Consultation Response from: KC Environmental Health (Pollution & Noise Control)		
2020/90640 - Holmfirth High School, Heys Road, Thongsbridge, Holmfirth, HD9 7SE		
Formation of artificial grass pitch with associated features, including eight 15m high floodlights, fencing up to 4.5m, pedestrian circulation and access route, vehicular maintenance and emergency access with Springwood Road, erection of store, grass mounds, retaining structures and landscaping works		
Date Responded: 04 May 2020	Responding Officer: Richard Hume	Responding Ref: WK/202006877
Noise A “Noise Impact Assessment Report” by Acoustic Consultants, dated 10 Jan 2020 (Ref: 8082/DO) has been submitted. The report predicts the noise levels that will occur at nearby noise-sensitive properties by using measurements of noise from sports activities at existing similar sports facilities and compares those levels with measurements of the existing noise levels within the site. It advises that the proposals are for the development to be open for use, including use by the community, from 9:00 until 22:00 Monday to Friday and until 17:00 on Saturday, Sunday and Bank Holidays. The assessment predicts highest noise level at the

# HORIZONTAL FLOODLIGHT ILLUMINANCE

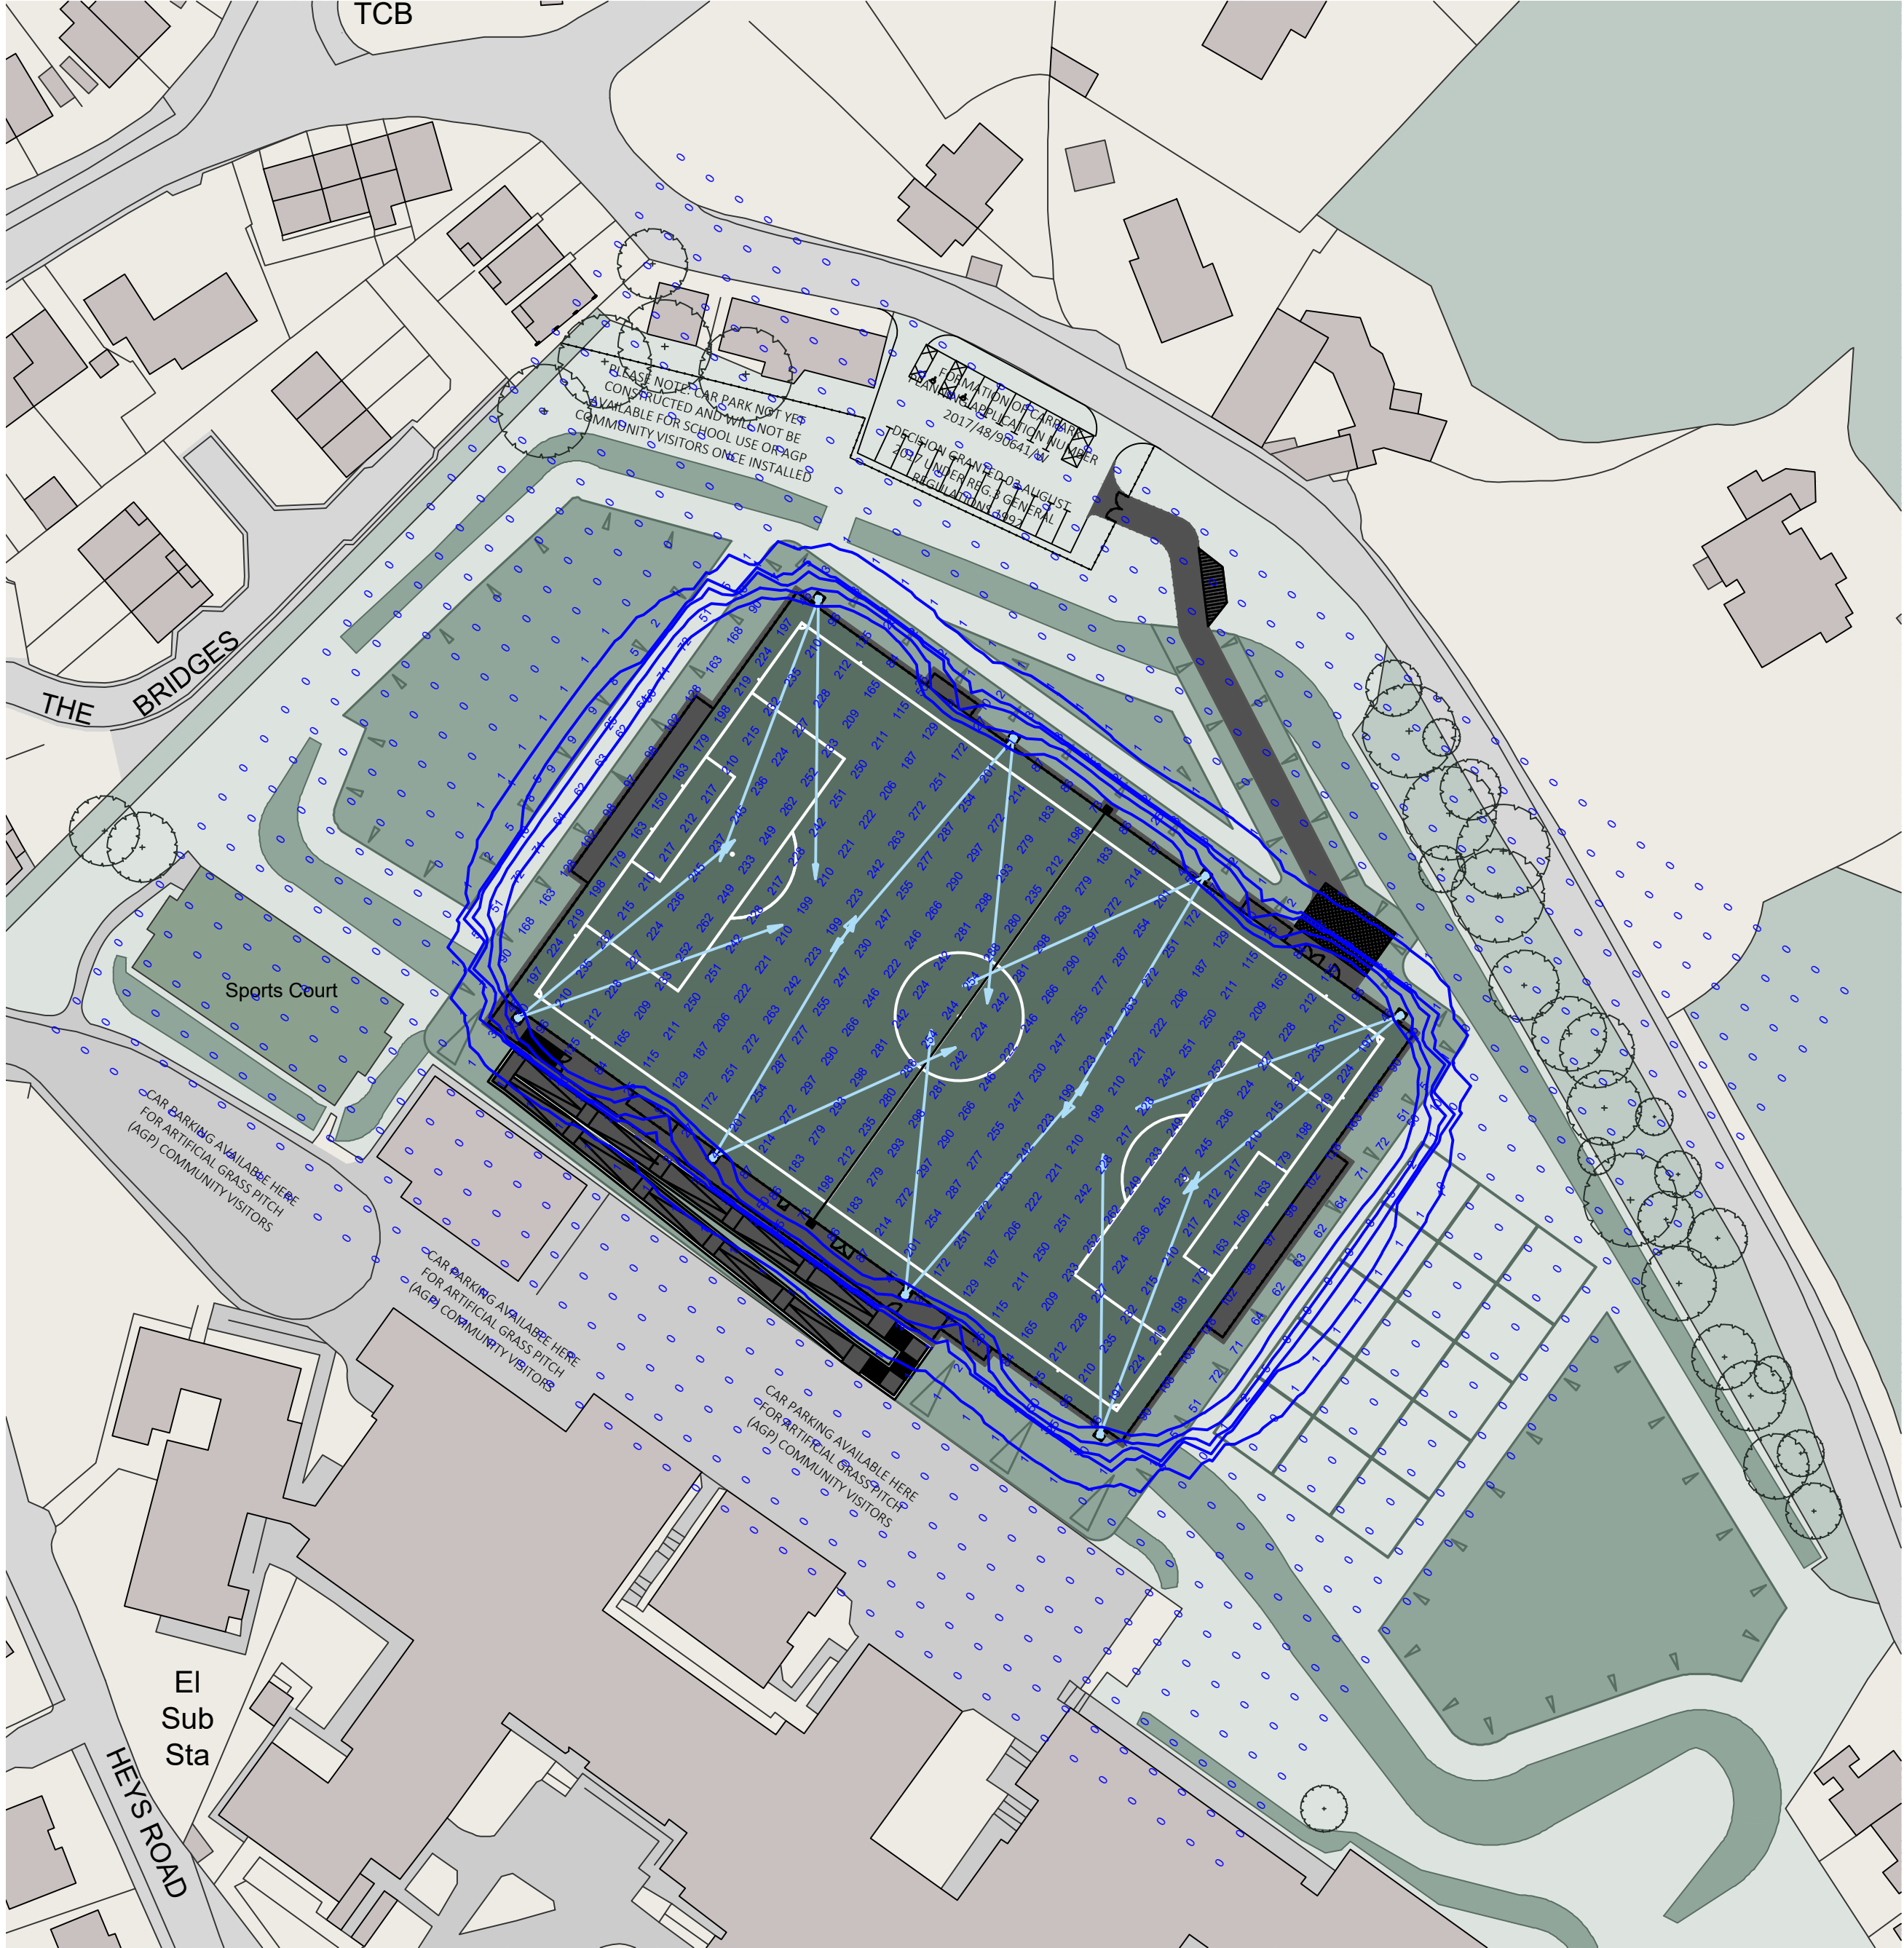
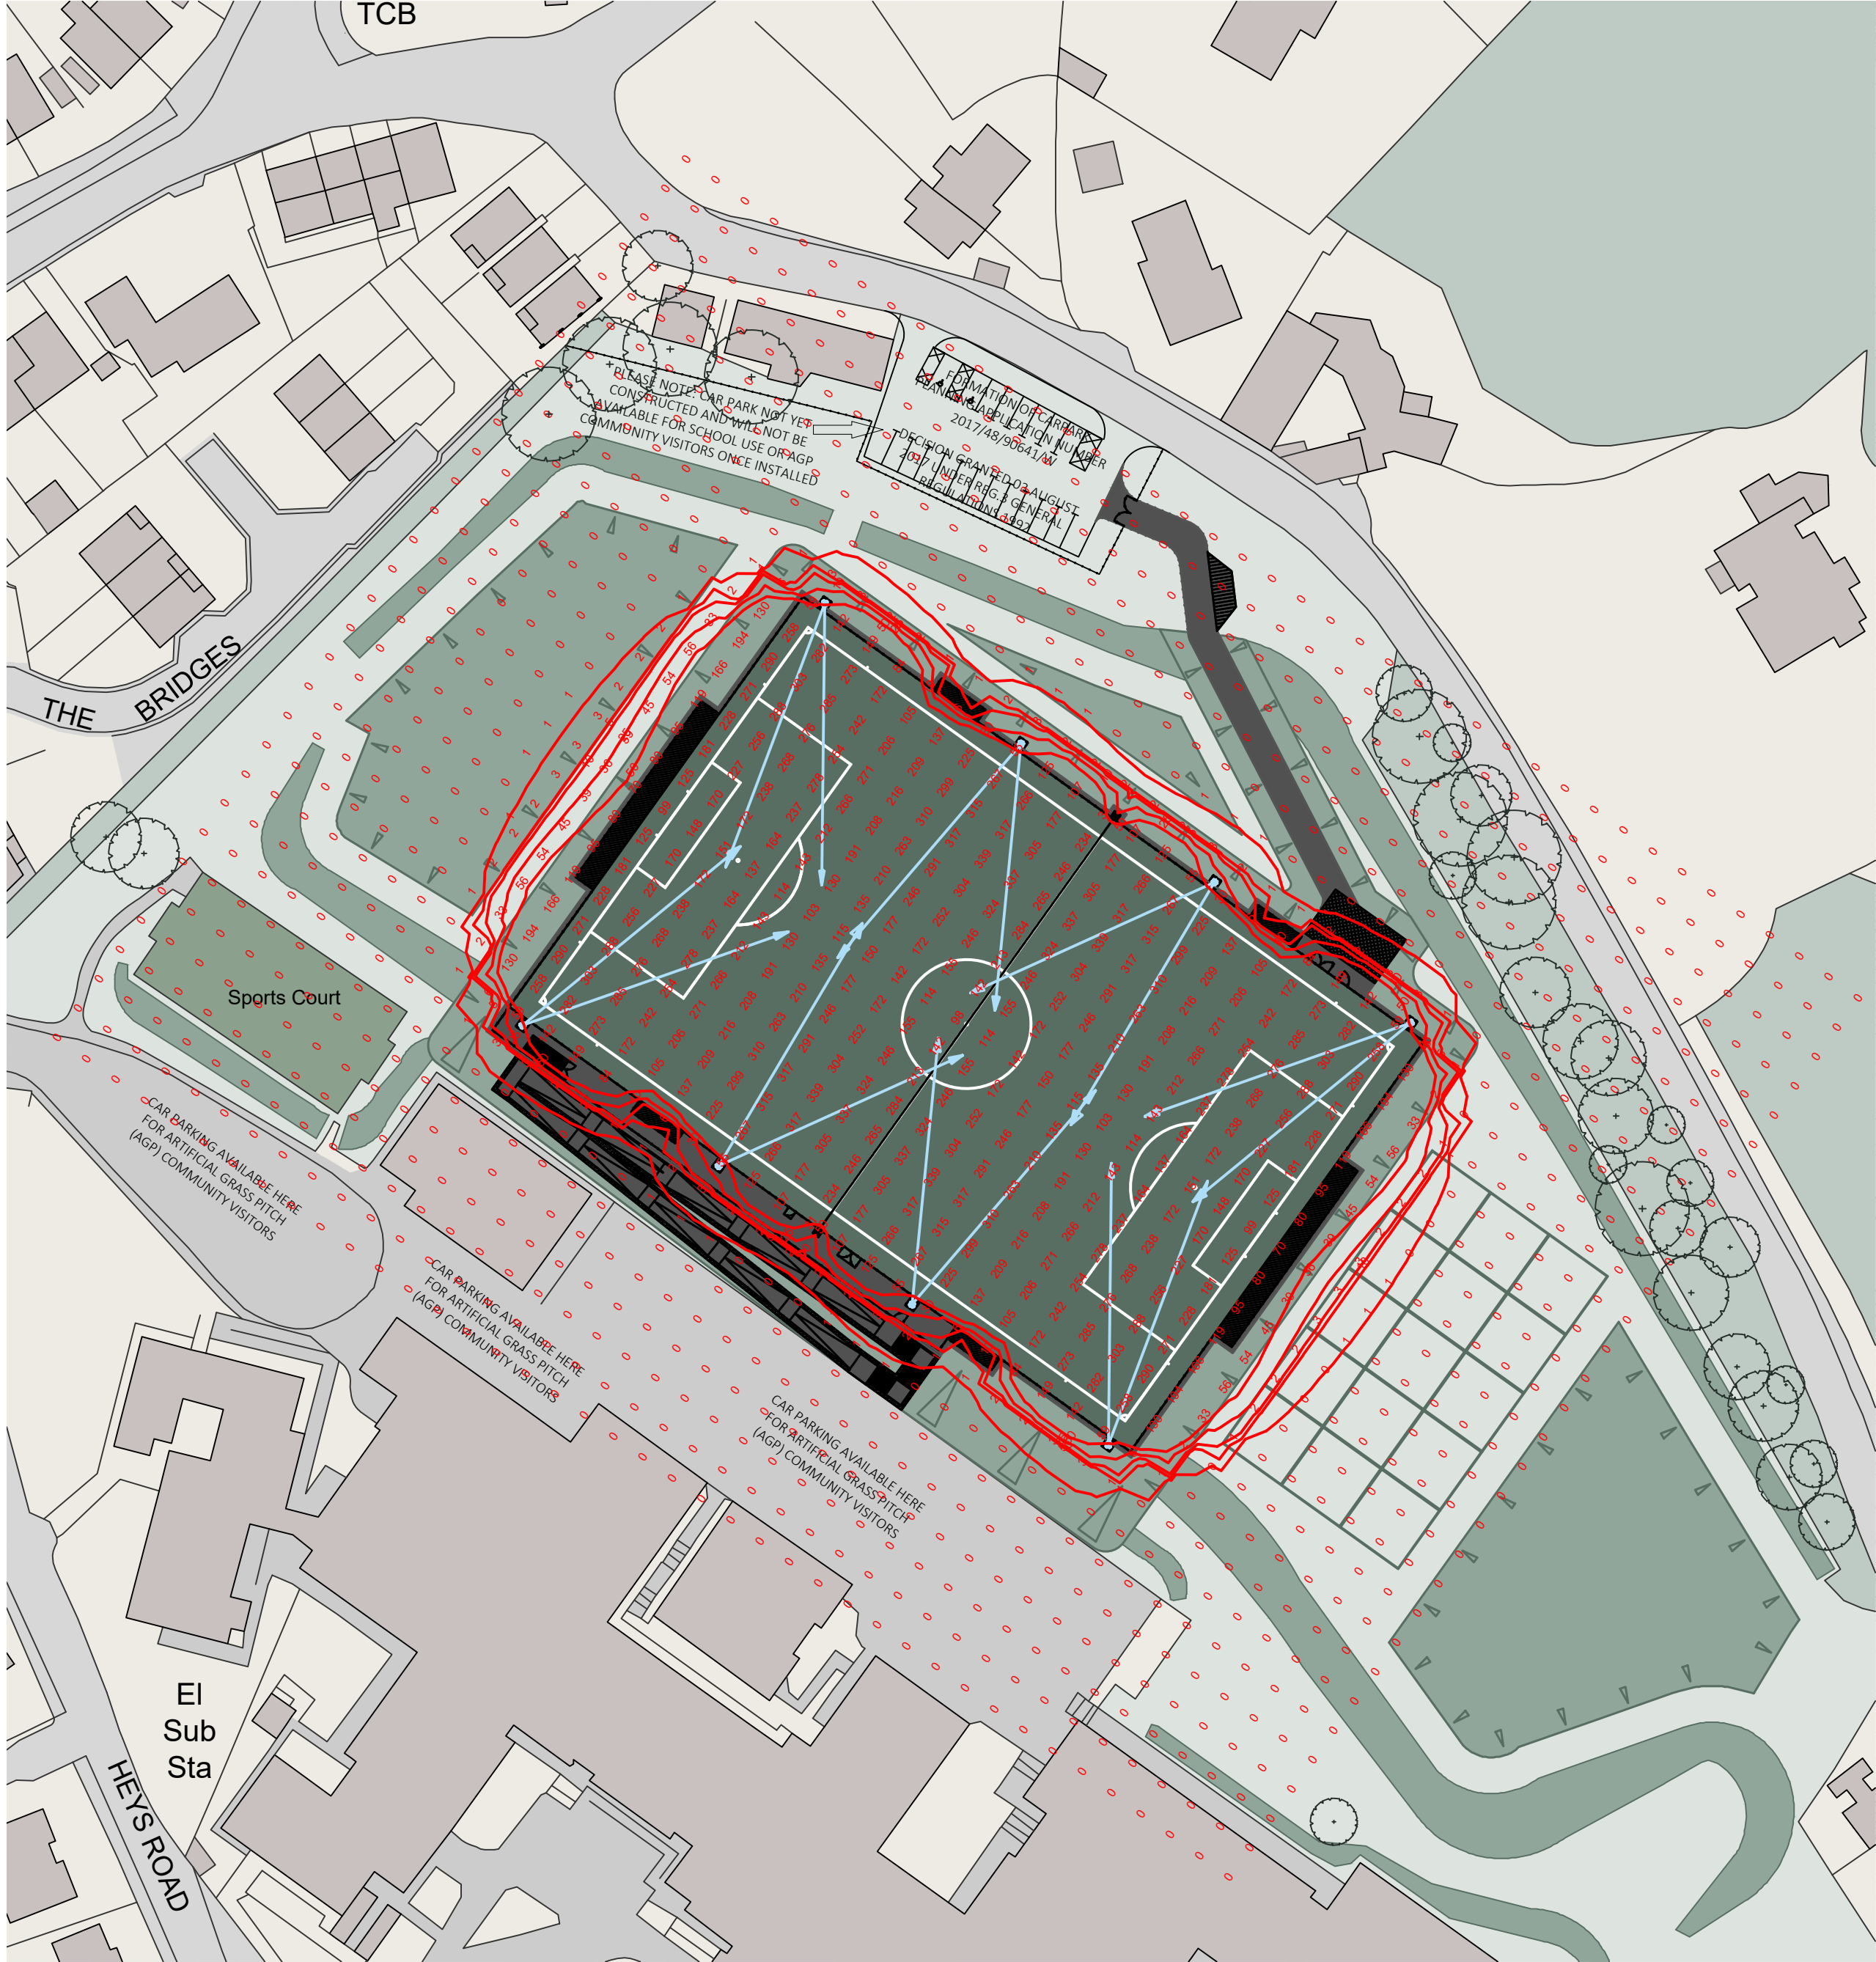
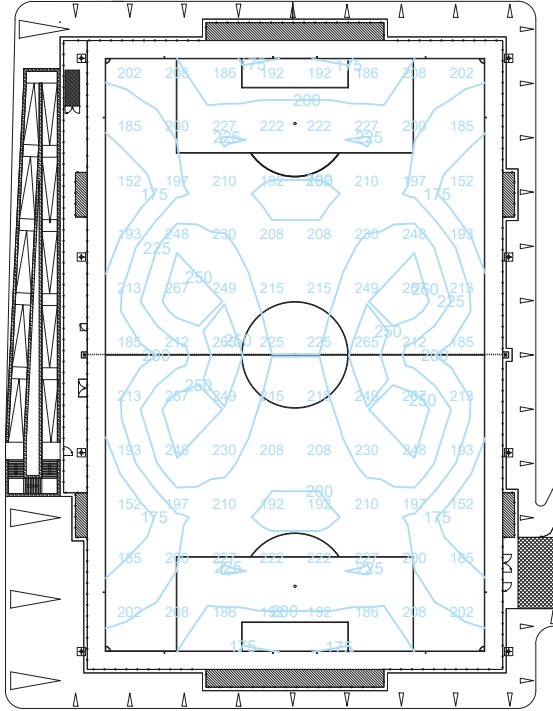
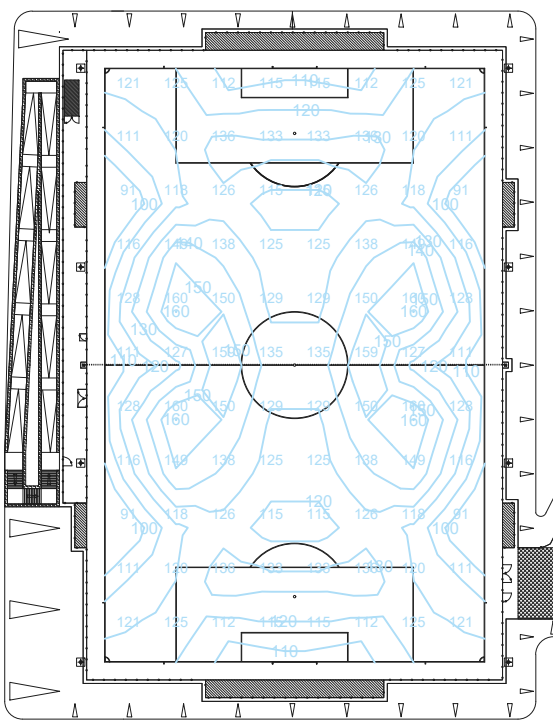
There are some concerns regarding the proposed and predicted levels of illuminance. The football association guidance which has been used for the design levels of illuminance is intended for lighting installations for Clubs wishing to compete in FA competitions and in the National League System. The British Standard referred to in the submitted document (BS EN 12193 (2018) Light and Lighting - Sports Lighting) provides different guidance, recommending illuminance levels of 75 lux for a development of this type.

I therefore consider that the proposed illuminance levels are significantly higher than are necessary for the intended future use and therefore unacceptable. A condition requiring revised proposals for the artificial lighting are therefore necessary.

Before the installation of external artificial lighting commences, a lighting scheme shall be submitted to and approved in writing by the Local Planning Authority. The scheme should include the following information:-

- a) The proposed hours of operation of the lighting
- b) The location and specification of all of the luminaires
- c) The proposed design level of maintained average horizontal illuminance for the areas that needs to be illuminated.
- d) The predicted vertical illuminance that will be caused by the proposed lighting when measured at windows of any properties in the vicinity.
- e) The measures that will be taken to minimise or eliminate glare and stray light arising from the use of the lighting that is caused beyond the boundary of the site
- f) The methods of switching and controlling the lighting so that it is only operated at the permitted times and at times when it is required.
